# Building R1 (SSD 6513)

## Attachment A – Detailed Response to Submissions

Response to Schedule 1: Additional matters identified by the Department of Planning and Environment.

Site Locality Plan

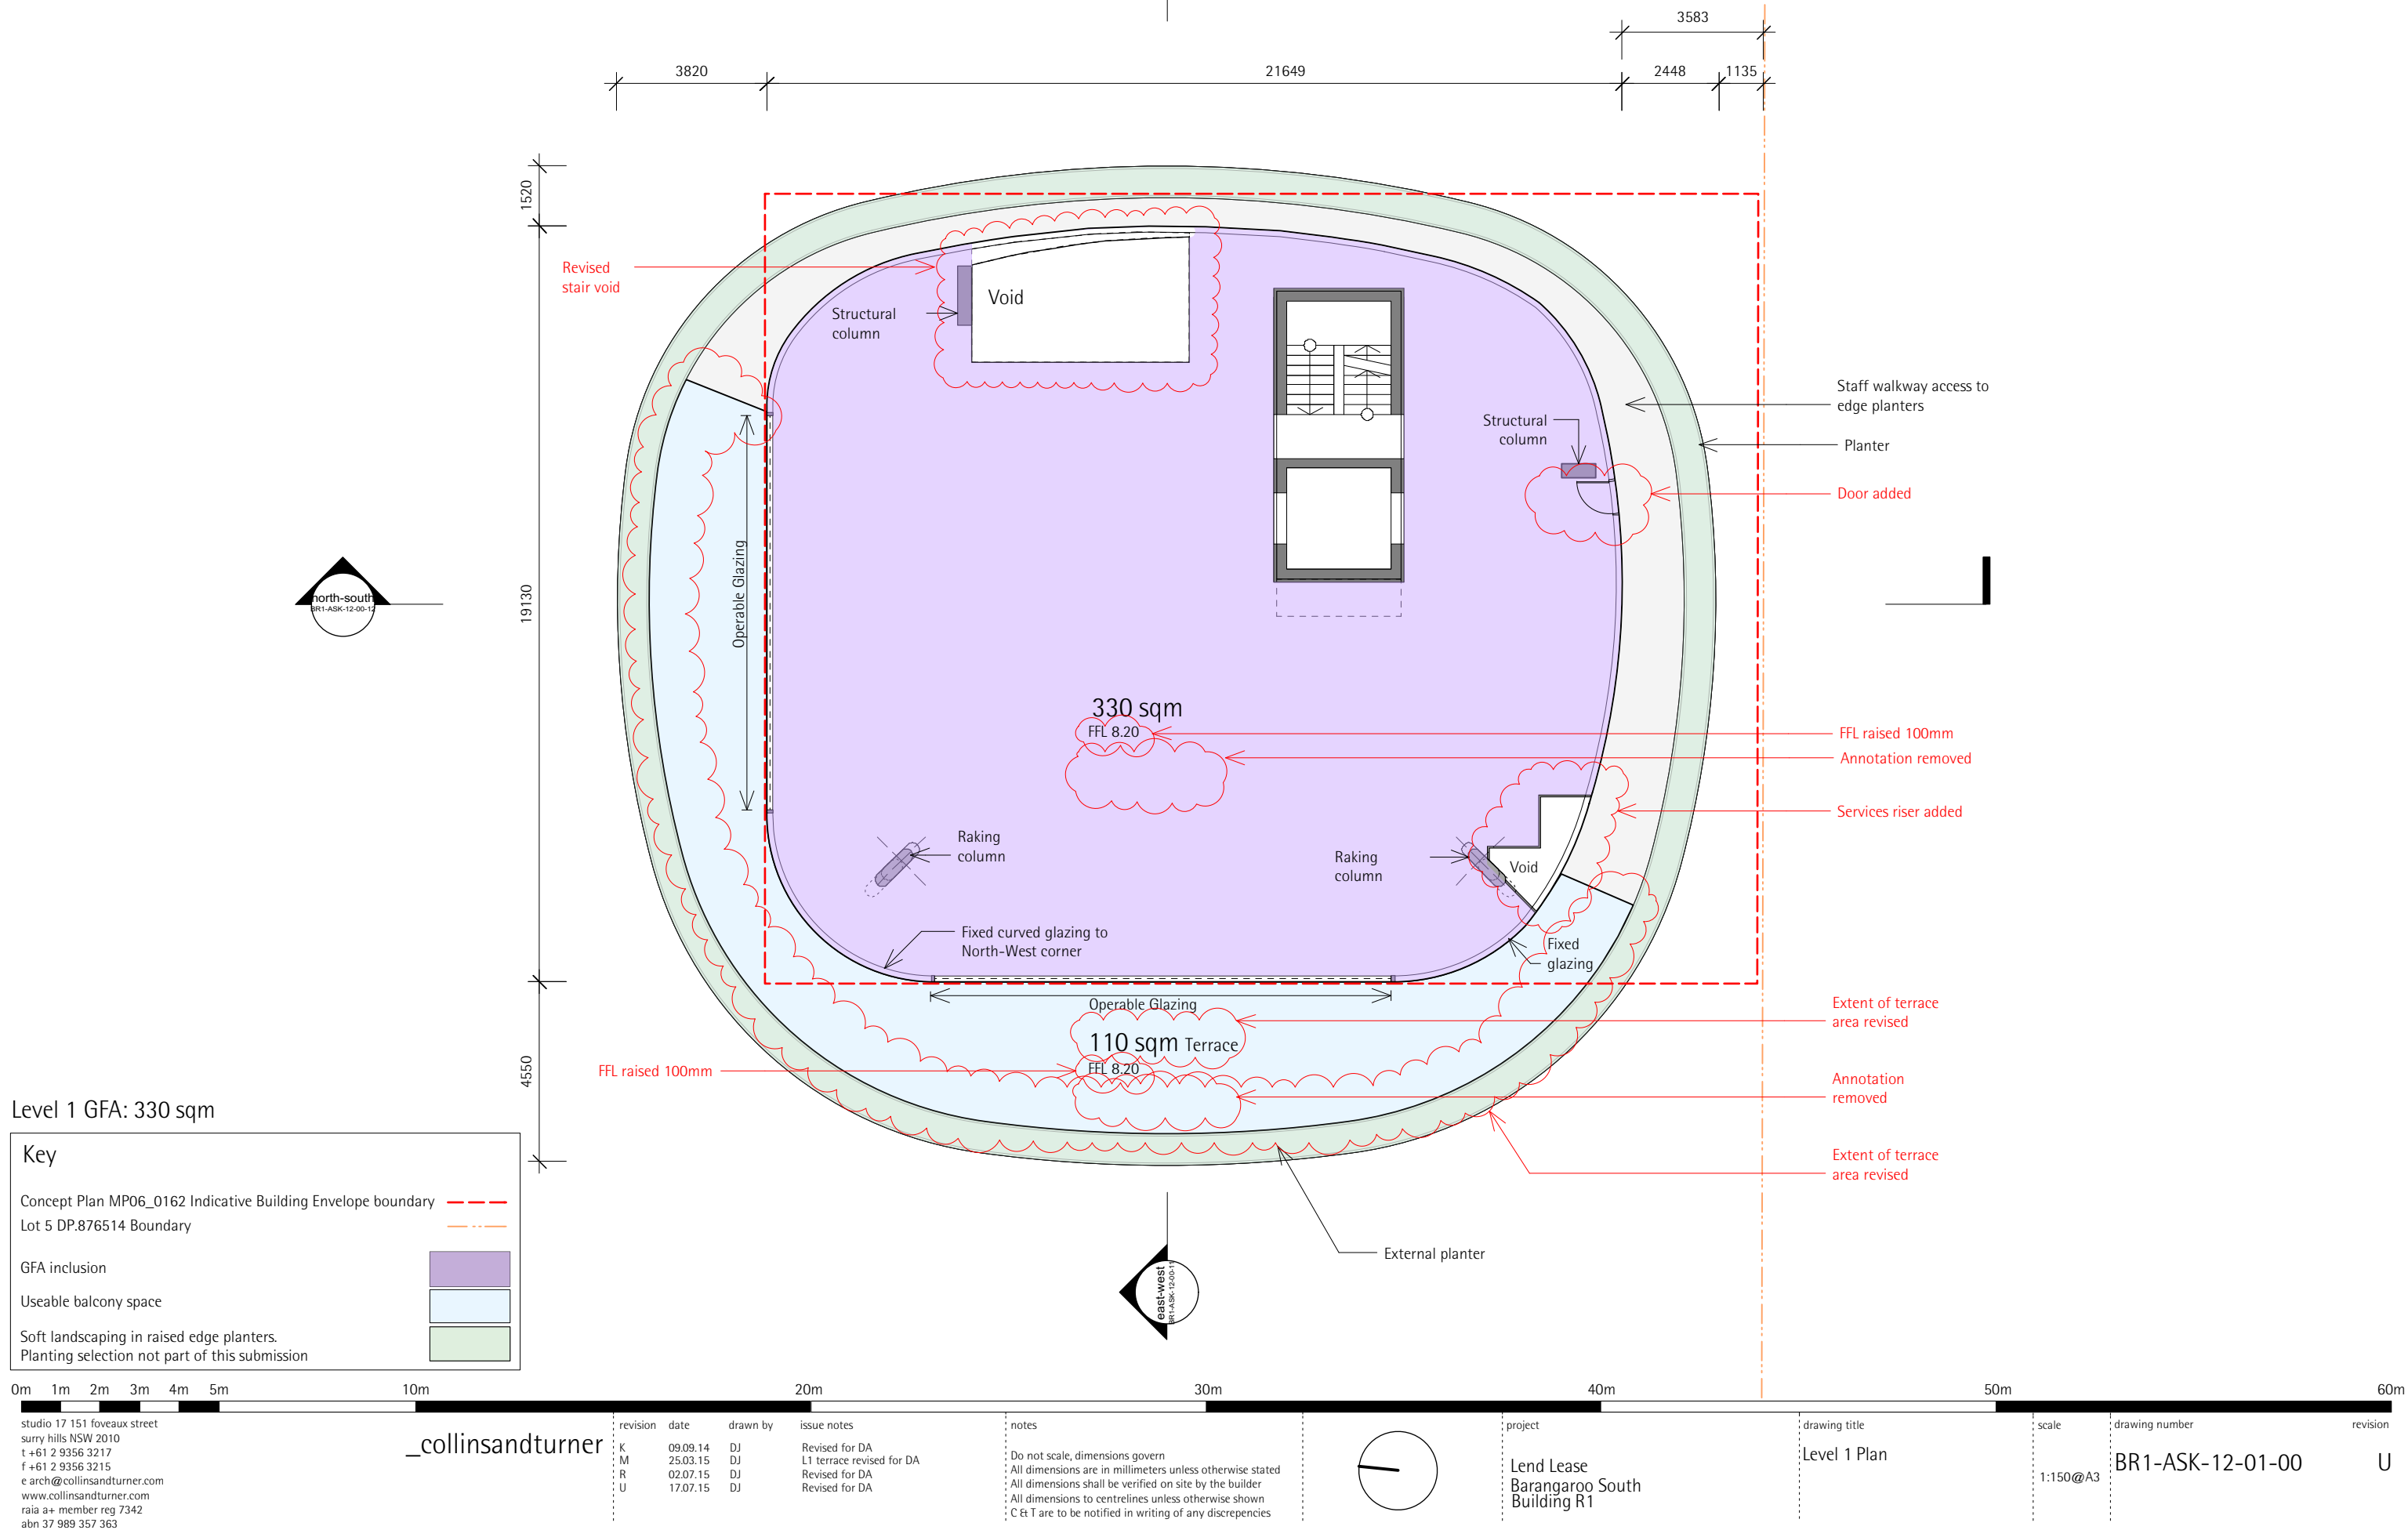
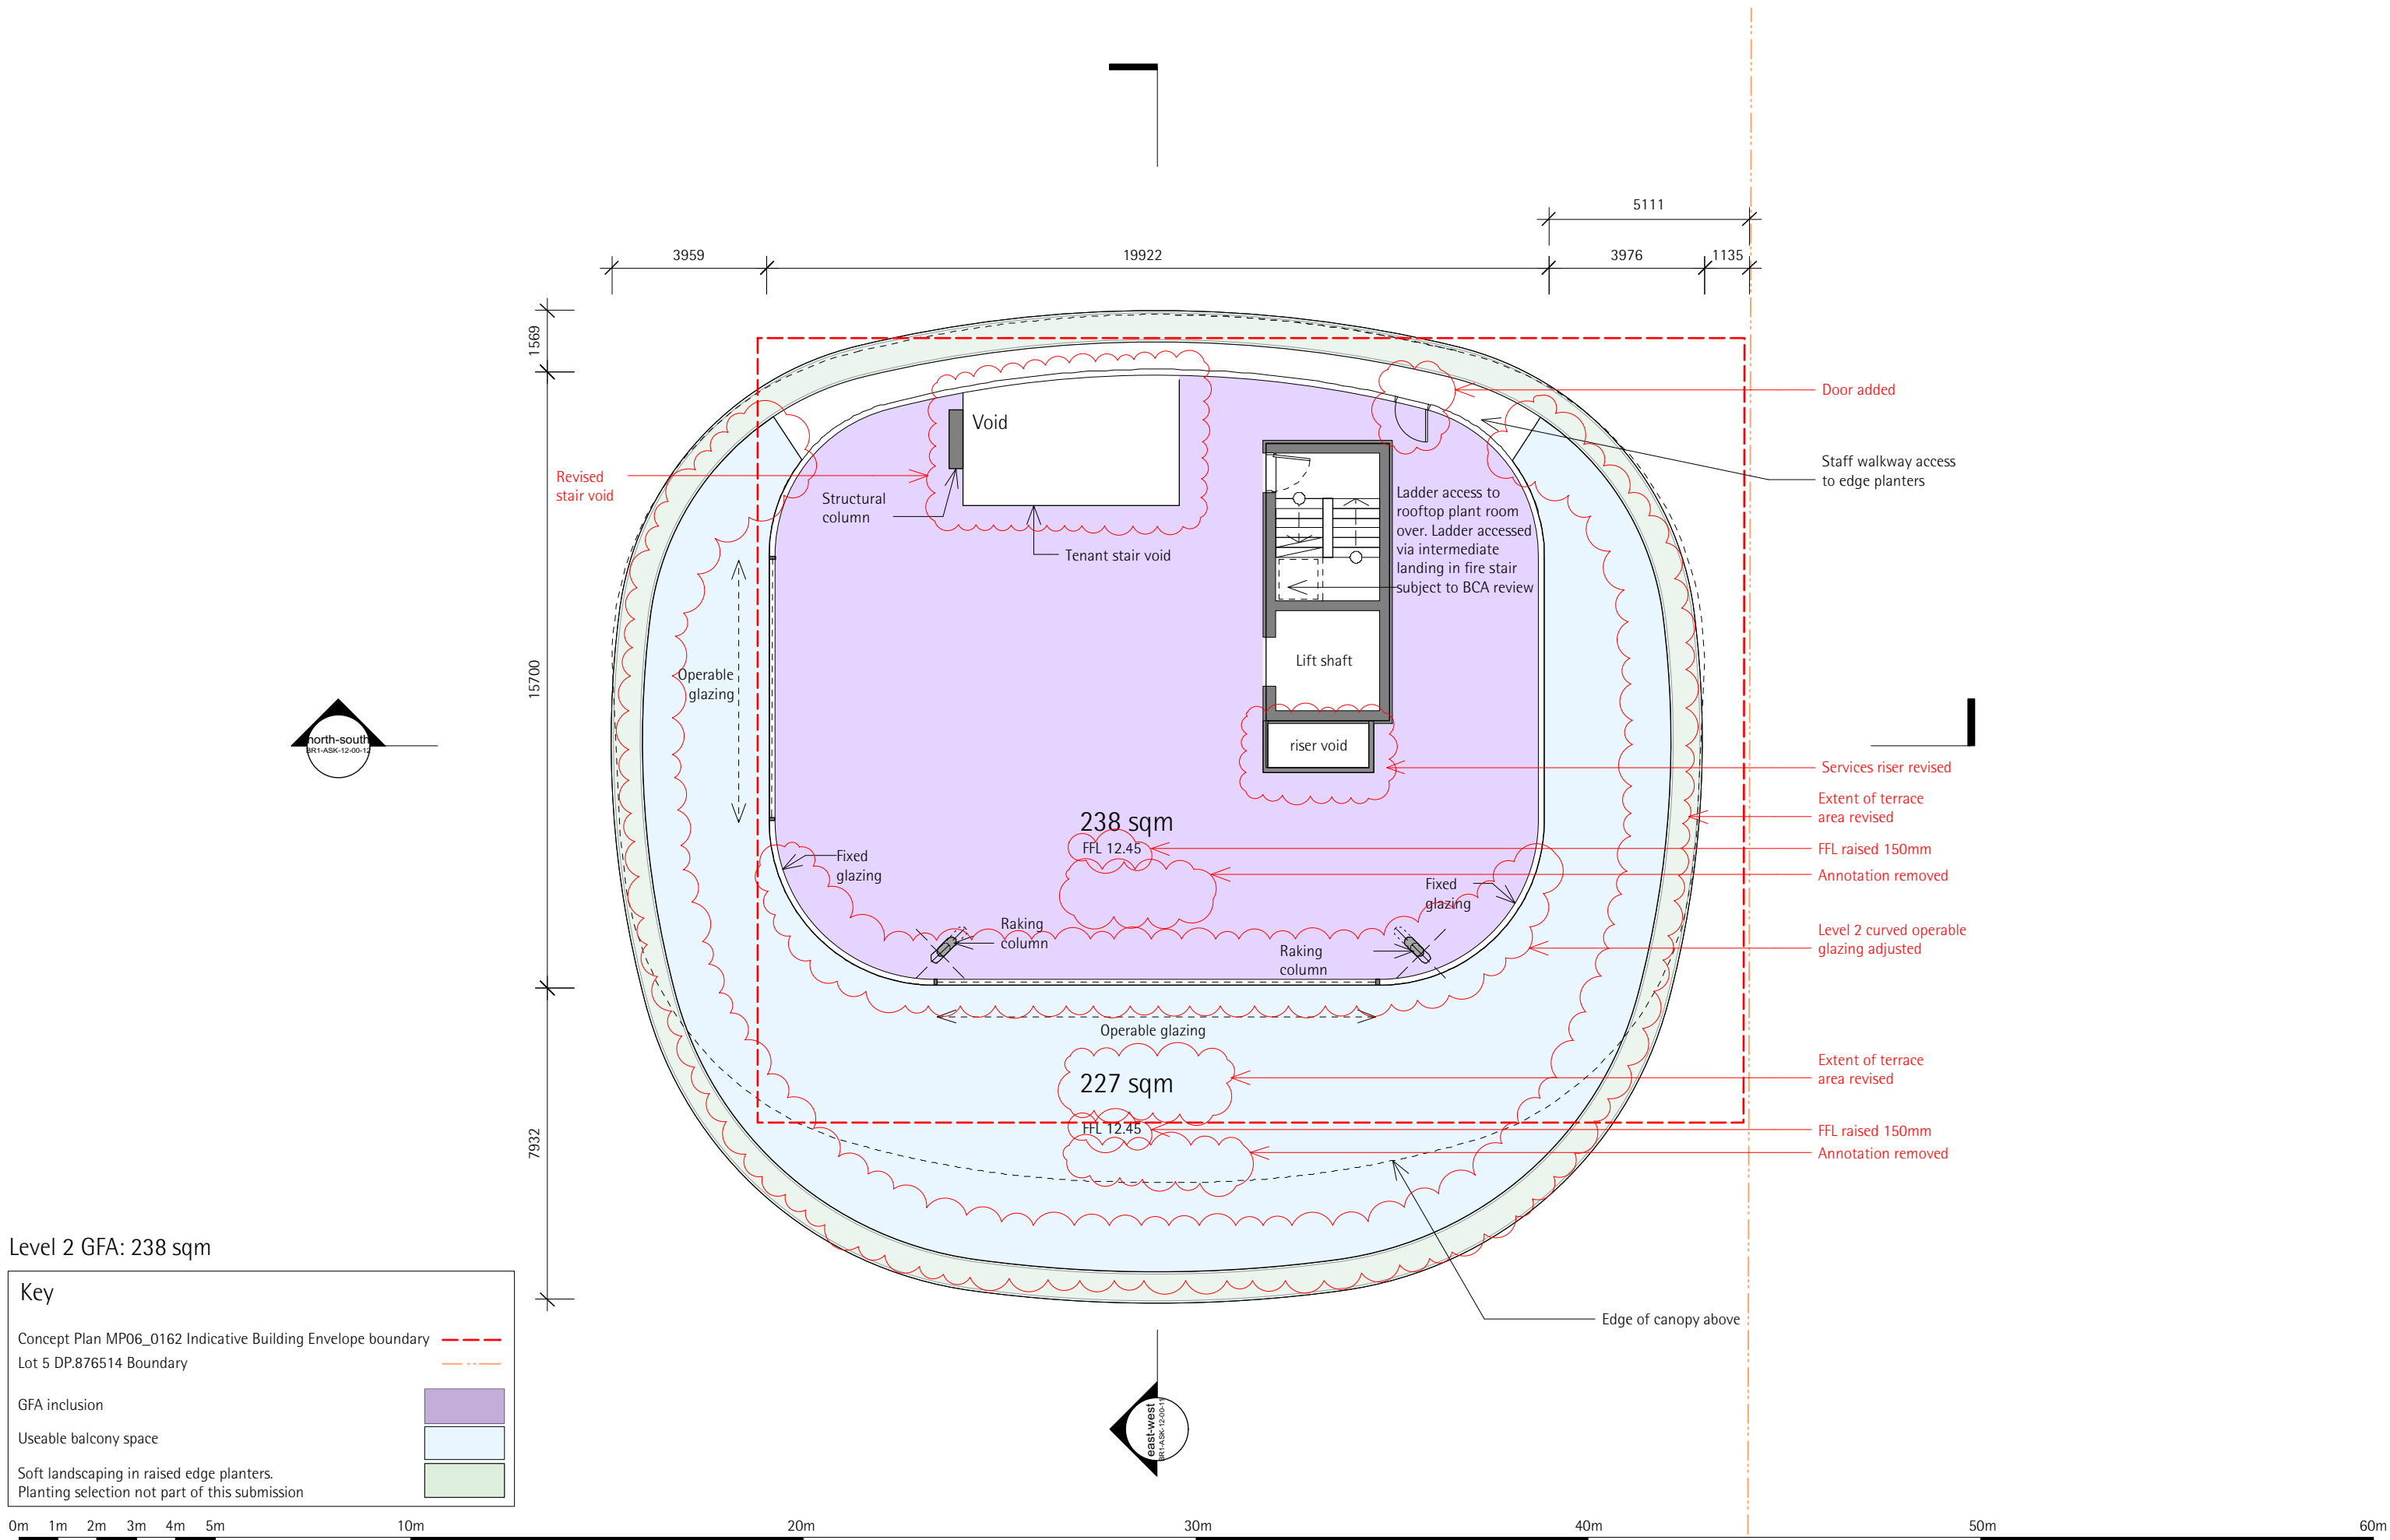
| Issue                                  |  | Lend Lease Response   |
|--|--|---|
| 1                                      | <p><b>Architectural Plans</b><br/>The architectural plans need to include a site layout plan that shows how the building sits on the site relative to Transport Place, R7, and R8 and R9. The plan must be provided at an appropriate scale.</p>   | <p>A site location plan was provided with the Architectural Drawings (refer to plan BR1-ASK-12-04-05). This plan illustrates the immediate surrounds of the building, including Buildings R8, R9, R7, C5 and C4. The plan is provided at a scale of 1:500 (A3). A smaller insert on BR1-ASK-12-04-05 illustrates the wider context of the proposal in the Barangaroo Site. This level of detail is commensurate to past applications at Barangaroo South.</p>   |
